1 February 2019

**Mount Owen Continued Operations Project - Modification 2 (SSD 5850 MOD 2)  
Response to Submissions**

I refer to your email to the Environment Protection Authority (EPA) dated 7 January 2019 inviting the EPA to comment on the "Mount Owen Continued Operations Project Modification 2 Response to Submissions" (the RTS) prepared by Umwelt for Glencore and dated December 2018.

Figure 21 Predicted number of days above $50 \mu\text{g}/\text{m}^3$ PM_{10} due to the Proposed Modification

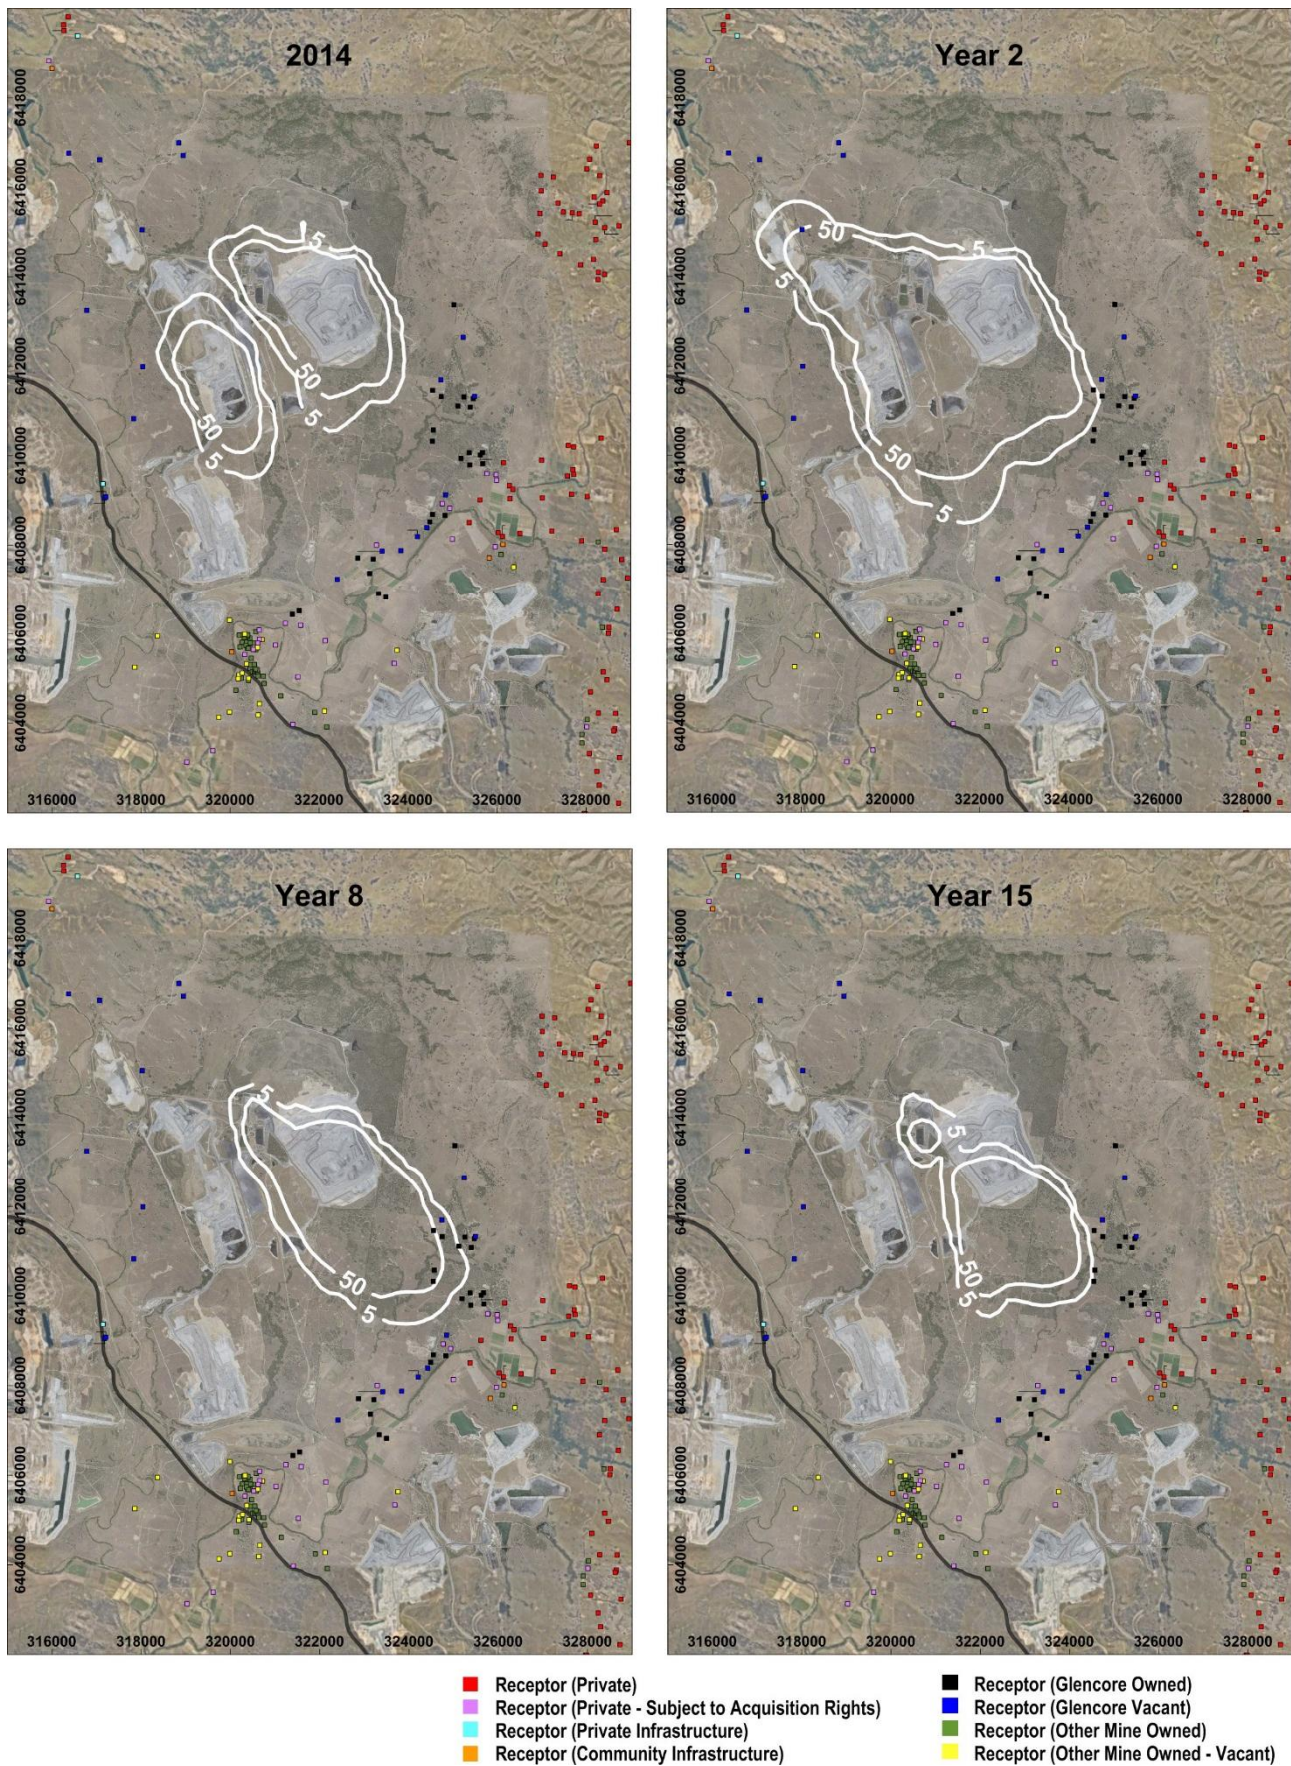
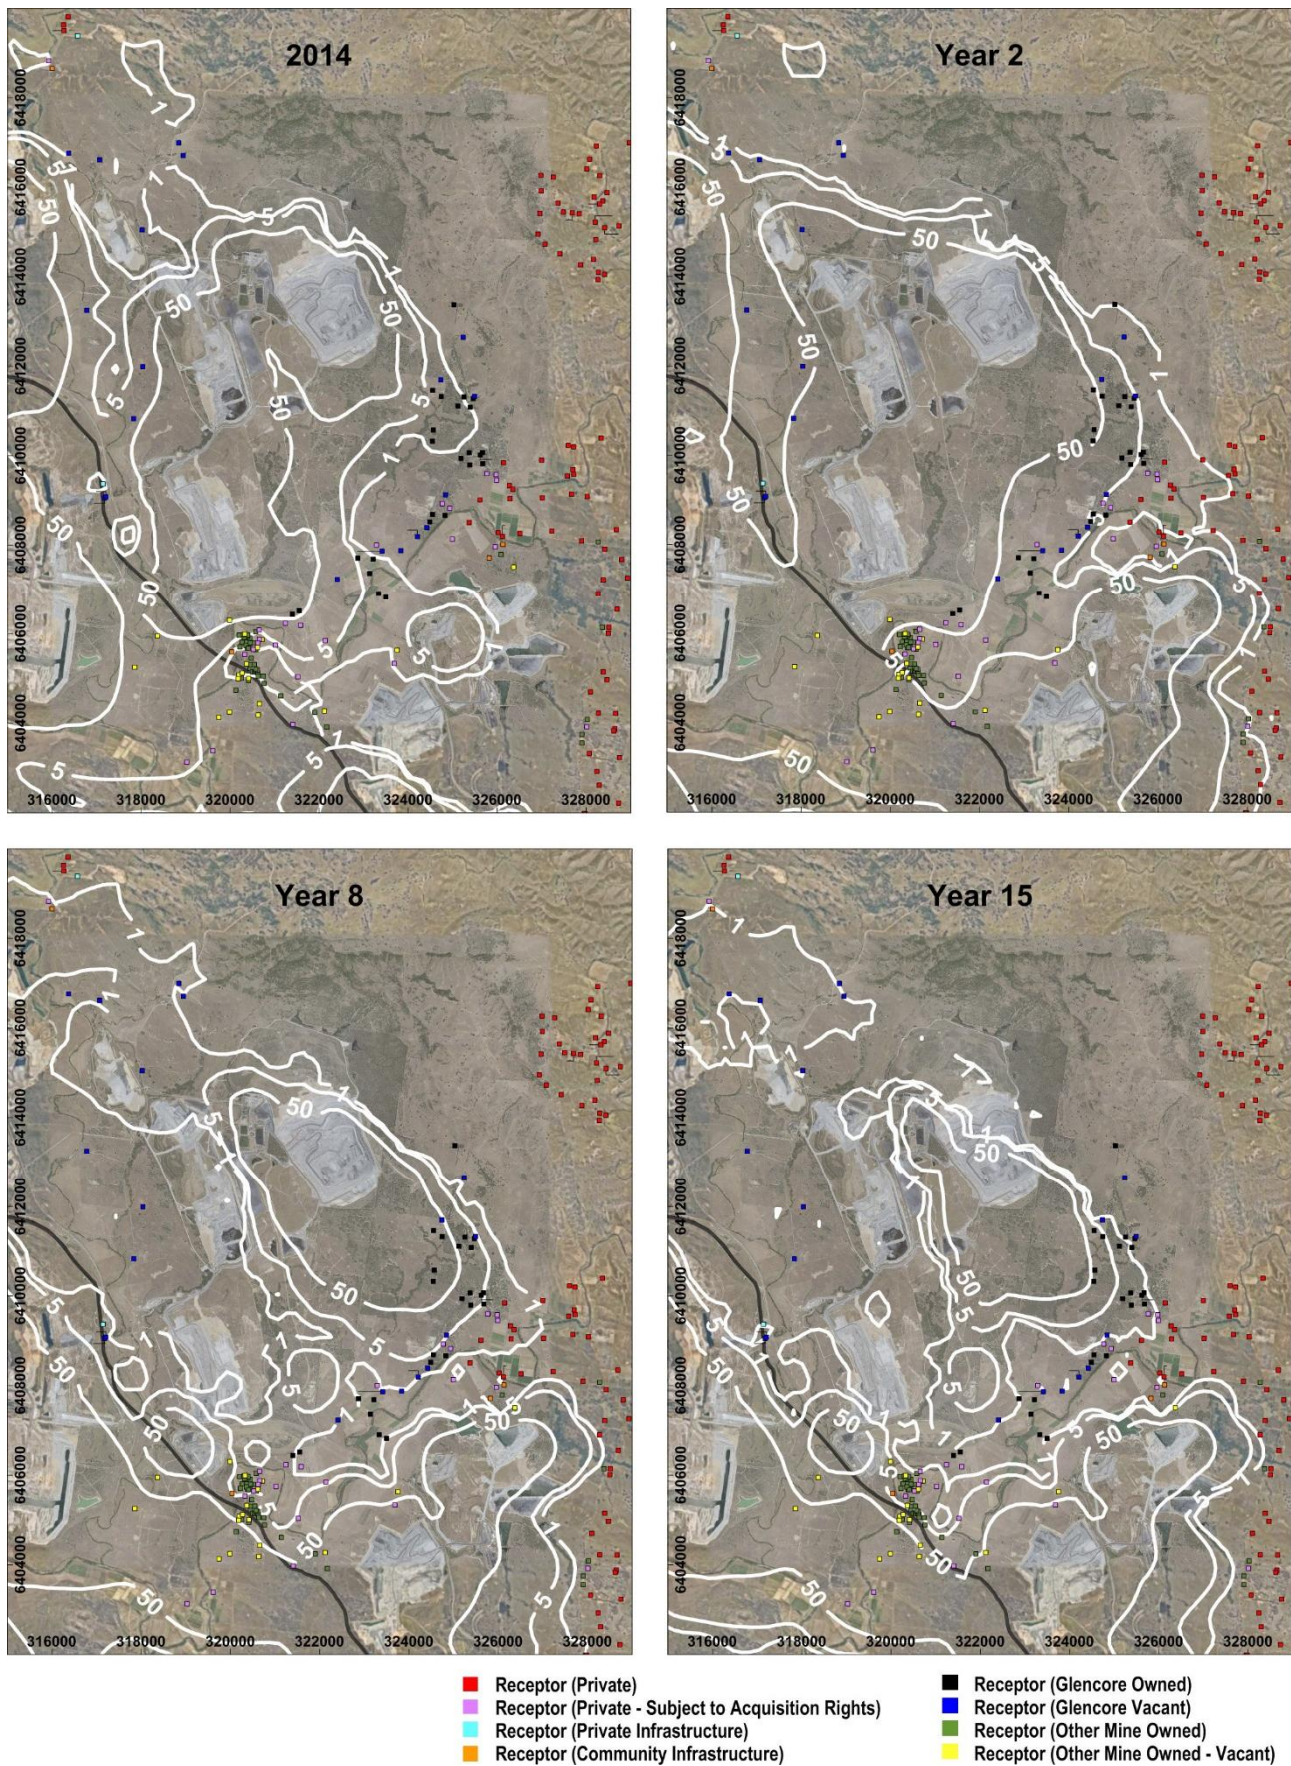
- PM<sub>10</sub> (24 hour) average cumulative concentrations are predicted to exceed the EPA's impact assessment criterion at 48 private sensitive receptors without acquisition rights. Further, the predicted exceedances at 21 of these receptors could be attributable to the proposed modification. This is based on a comparison of the predicted cumulative ground level concentrations for various mines in the areas (excluding Mt Owen) as compared with predicted ground level concentrations for all sources assessed (including Mt Owen). Between, 1 to 3 additional exceedance days are predicted for these receptors.

The predicted PM<sub>10</sub> contributions from the Mt Owen operations account for between 2 and 22 % of the predicted cumulative 24-hour PM<sub>10</sub> ground level concentration, where additional exceedance days are predicted.

The RTS contains little information on the proposed measures to manage the predicted additional exceedances other than advising that revisions to the Air Quality Management Plan would be undertaken. The RTS advises that the modelling does not include reactive management measures that can be undertaken by Mount Owen.

Information Required – Prior to project determination, the proponent should provide further information to demonstrate that additional measures can be implemented to address all additional exceedances of the PM<sub>10</sub> (24-hour) criterion.
